Final Plat - Comment Response Letter

Citizen on Constitution
El Paso County, Colorado

Prepared: September 9th, 2022

**RE: Citizen on Constitution Filing No. 1
PCD File No. SF-22-06**

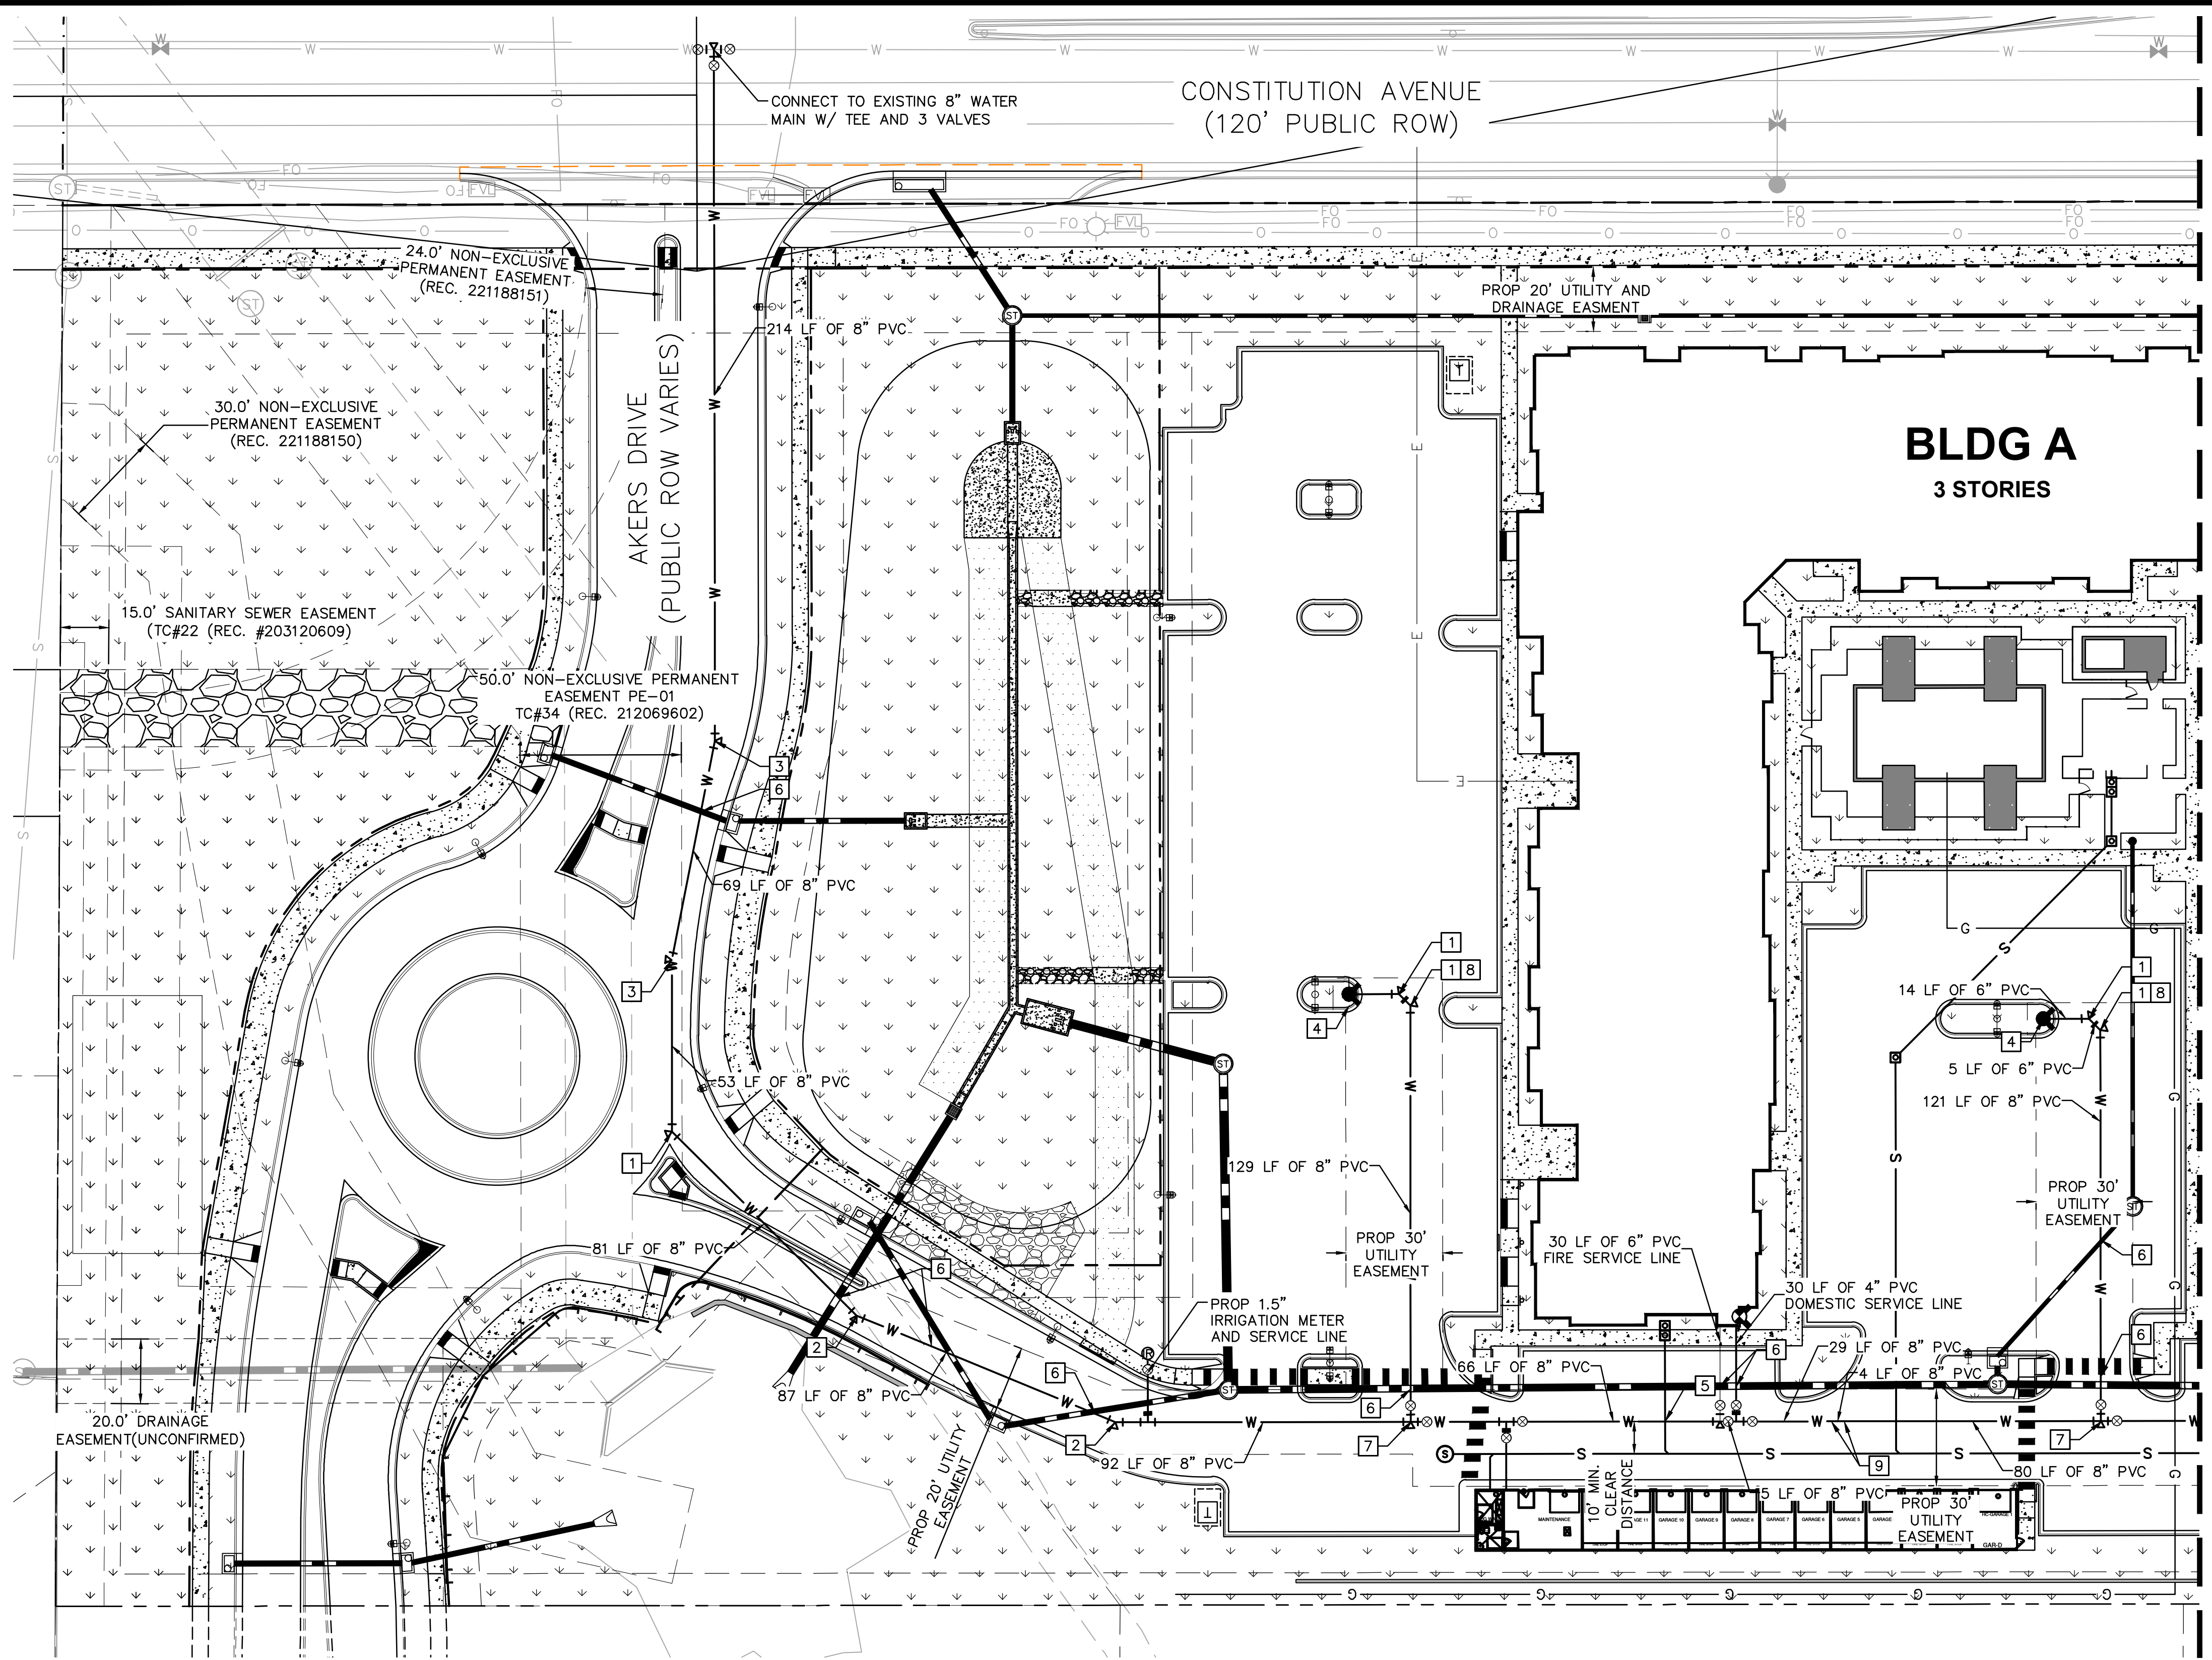
All mains for hydrants now show 2-45 deg bends rather than a single 90-deg bend

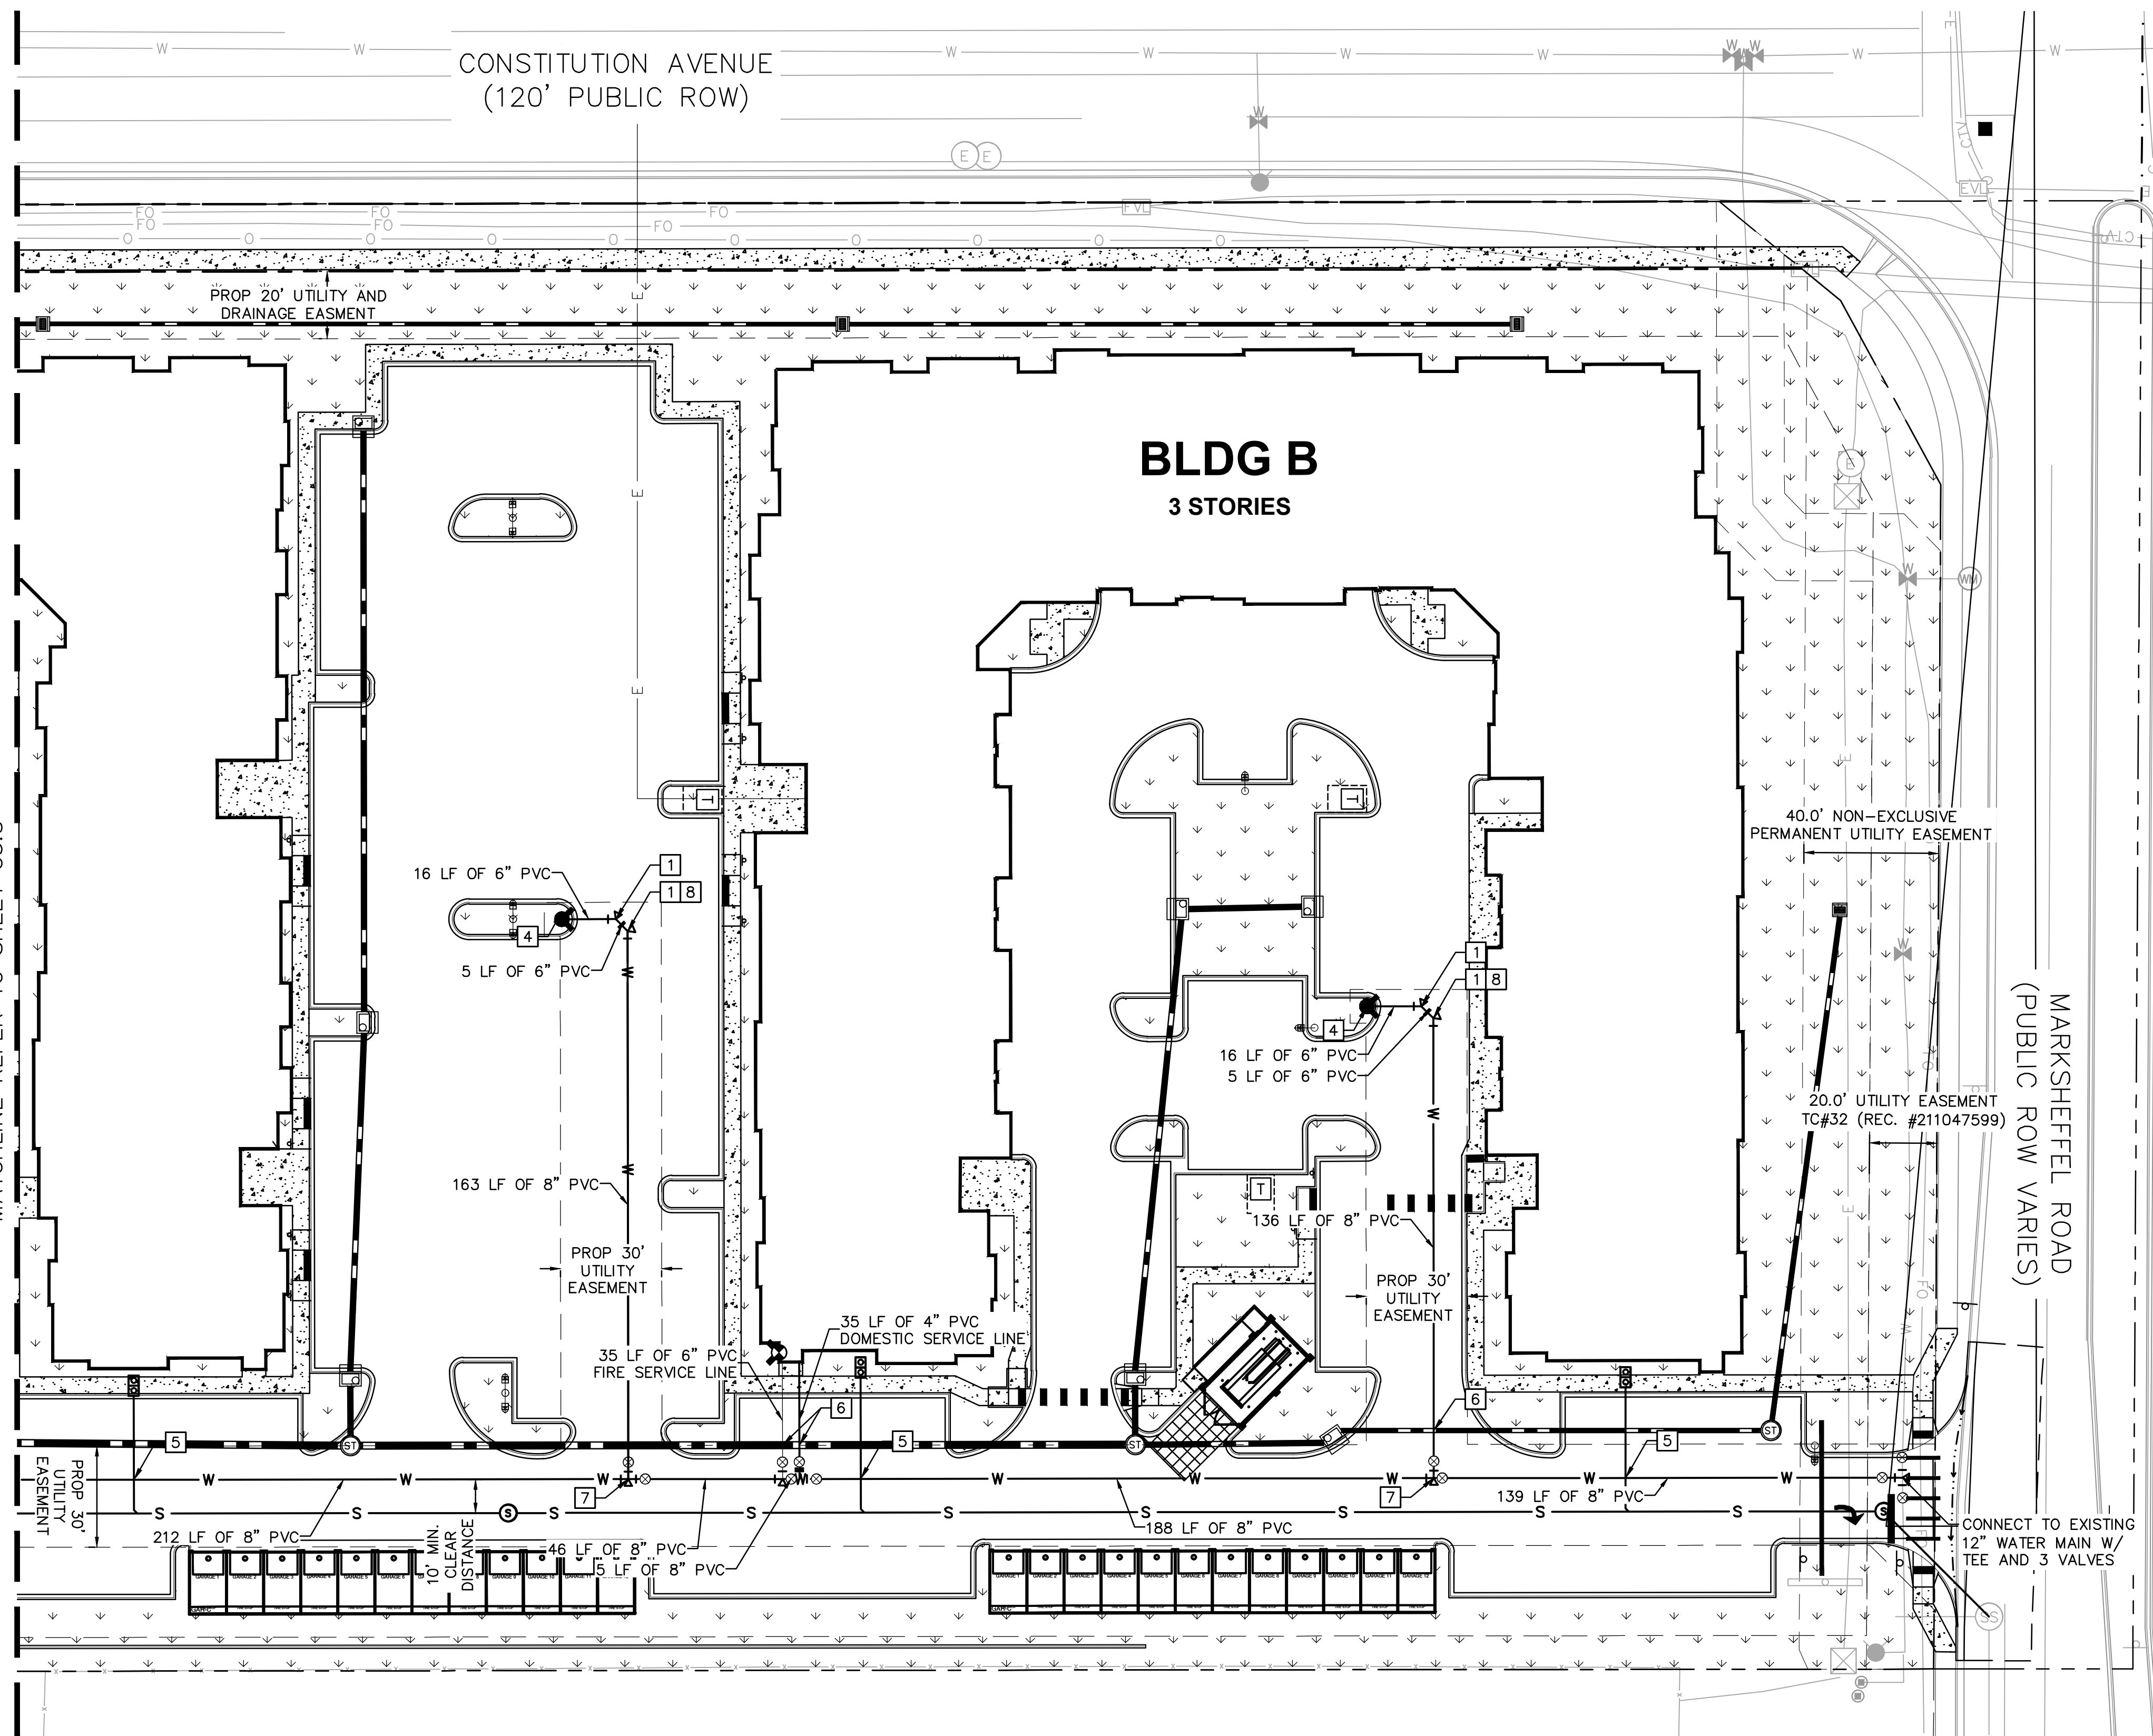
USE 2-45°
BENDS

EXISTING
LINE IS
12"φ

All mains for hydrants now
show 2-45 deg bends rather
than a single 90-deg bend

Connection now shows a
12" main in Marksheffel
